From: Robert Major
Sent: 21 June 2019 09:57
To: planning
Subject: FW: Longridge Road Hurst Green,app 19/0404

From: Bloomer, David [<mailto:David.Bloomer@lancashire.gov.uk>]
Sent: 18 June 2019 14:32
To: Robert Major
Subject: Longridge Road Hurst Green,app 0404

I have some concerns about this application that relate to the site layout and the car parking provision for the proposed development and also the existing properties numbered 8 and 8a.

A200

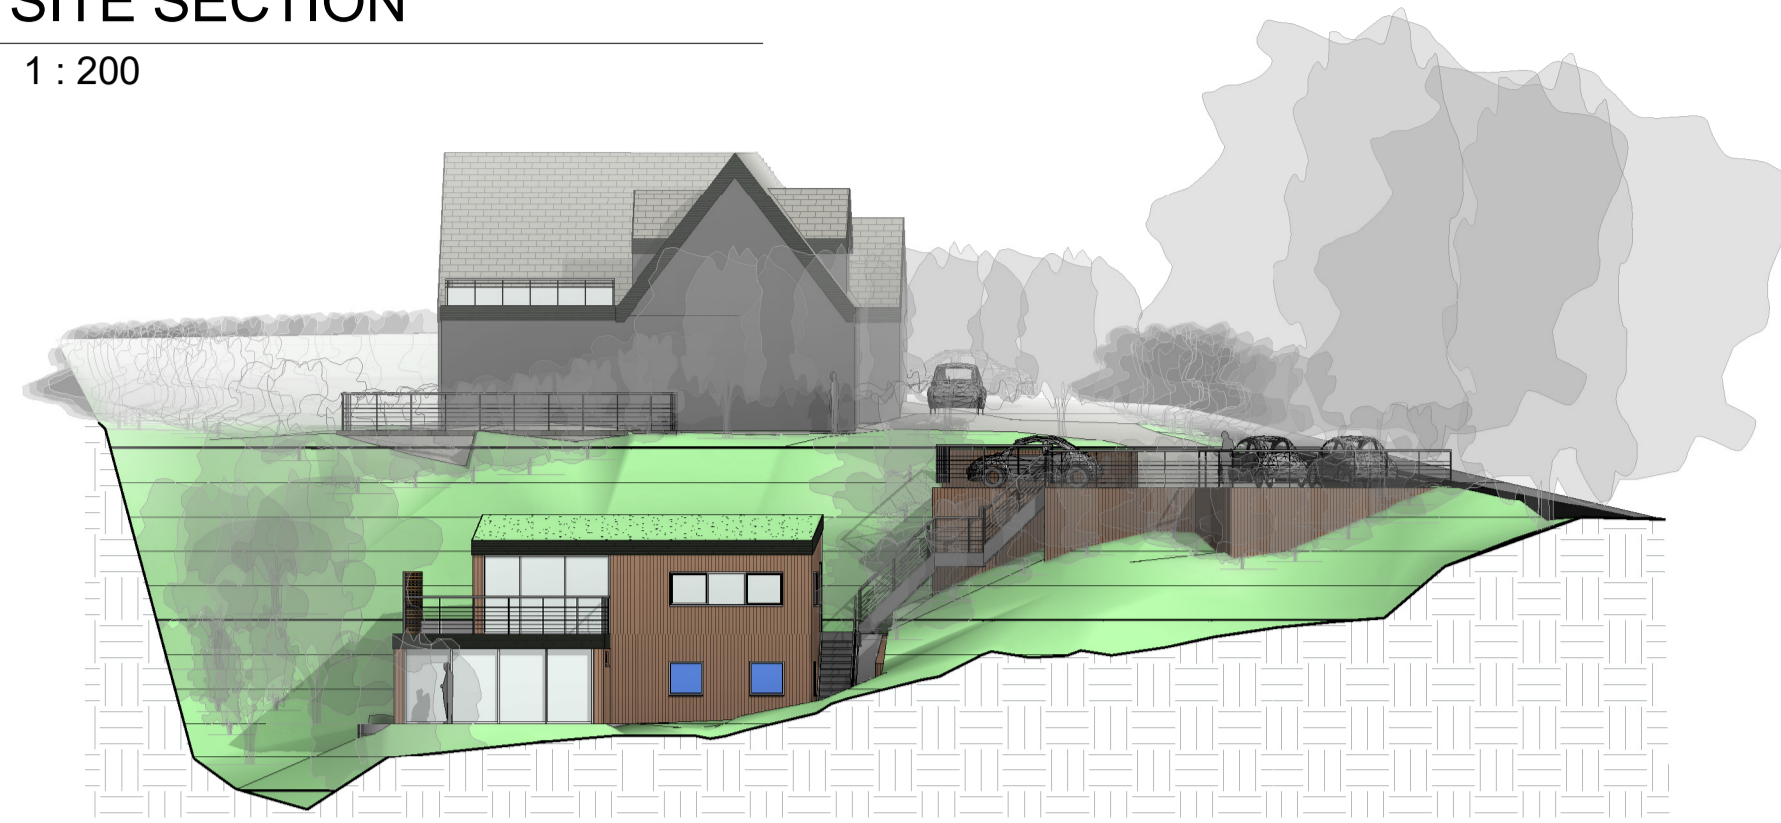
The proposed development is described as an ancillary office to replace an existing provision elsewhere within the site and also a gym and 1 bedroom. As proposed the standalone parking provision of 2 vehicles would be adequate. The applicant has indicated 3 parking spaces but this does not allow adequate manoeuvring space to allow vehicles to enter and leave in a forward gear. Turning to the parking provision for No. 8 from the plan submitted I can only accommodate 1 parking space on the plot without obstructing the access to the new development or the availability of a turning facility for vehicles visiting 8a.

The parking provision required is tied to the number of bedrooms for all 3 developments and I would therefore need to know the number of bedrooms at 8 and 8a and a useable parking layout showing the ability of all users to enter and leave the site in forward gear.
